Nicholson Place St Leonards Build-to-Rent (SSD-
88113706)

**46-52 Nicholson Street and 59-67 Christie Street,
St Leonards | Build-to-Rent**

This correspondence is submitted in response to the stormwater and flooding comments outlined in Attachment A of the Department of Planning, Housing and Infrastructure (DPHI) letter dated 17 December 2025, and the NSW State Emergency Service (SES) letter dated 10 December 2025. We trust that our response addresses the queries that have been raised.

Figure 5.7: 1% AEP Afflux / Change in Flood Levels at the site

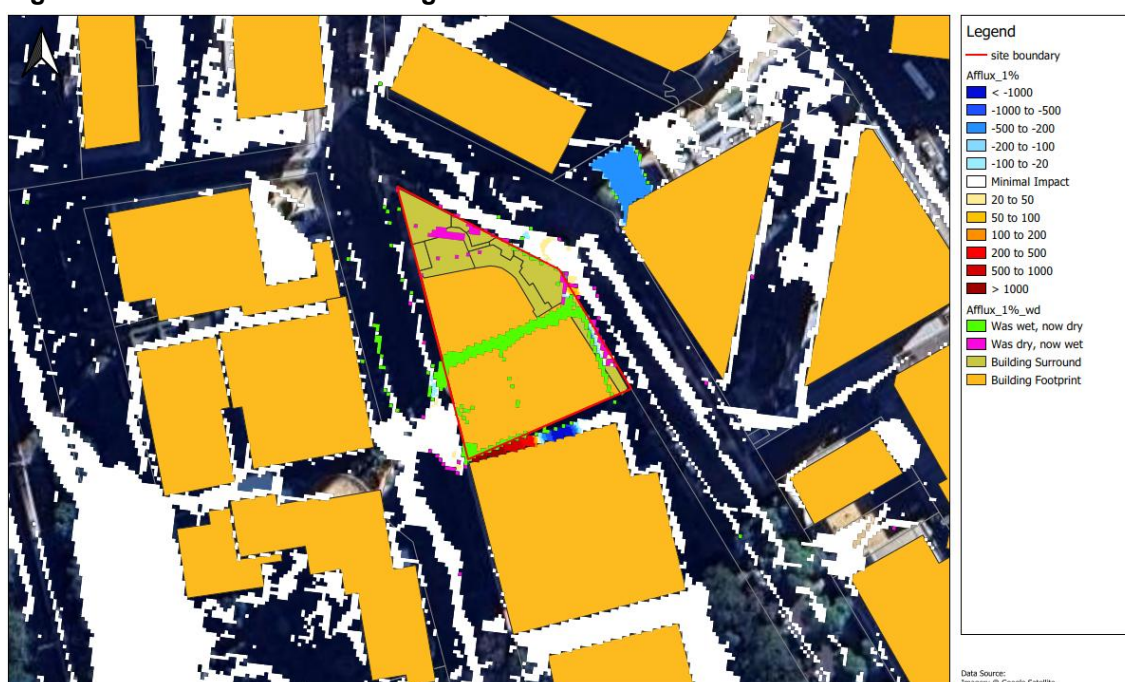
4	The Flood Impact Risk Assessment (FIRA)		17/12/2025	The proposed development will result in unacceptable flood impacts outside of the site boundary. The proposed building footprint extends to the boundary of 29-57 Christie Street and results in a significant increase in flood levels in this location. The previous building was not on the boundary and allowed for the escape of water flowing along the common boundary. The building footprint may need to be amended to reinstate the flow path near the Christie Street frontage to mitigate offsite impacts. Impact mapping has been provided for the 1% AEP event and is misleading because impacts of greater than 1m are included in a category labelled greater than 0.05m	Provide mitigation measures to ensure that offsite impacts are limited to no greater than 10mm in the 1% AEP event and no change in flood hazard or behaviour occurs in larger events. Provide afflux mapping for events greater than the 1% AEP event and provide a table which states the increase in depth offsite for each event modelled.	13-Feb-26	Jeffrey Mail	Flow path is provided by the proposed design to limit offsite afflux, and FIRA (C) updated with new colour scheme to detail these flood impacts with more colour ranges. Design seeks to minimise changes in flood hazard/behaviour in larger events SFAIRP through flow path provision to neighbouring building. Section 5.4 discusses how flooding in the narrow area to adjacent southern neighbour is essentially shifted towards Christie Street. There is also a large depth decrease associated with this shift and this pulls the ponding further west, away from the neighbour's external pathway and egress stairs which experiences the deep ponding in existing conditions. The FIRA (C) is updated with like-for-like baseline and post-mitigation comparisons, afflux mapping for >1% events, and a summar of maximum offsite depth increases for the 1% AEP and PMF events.
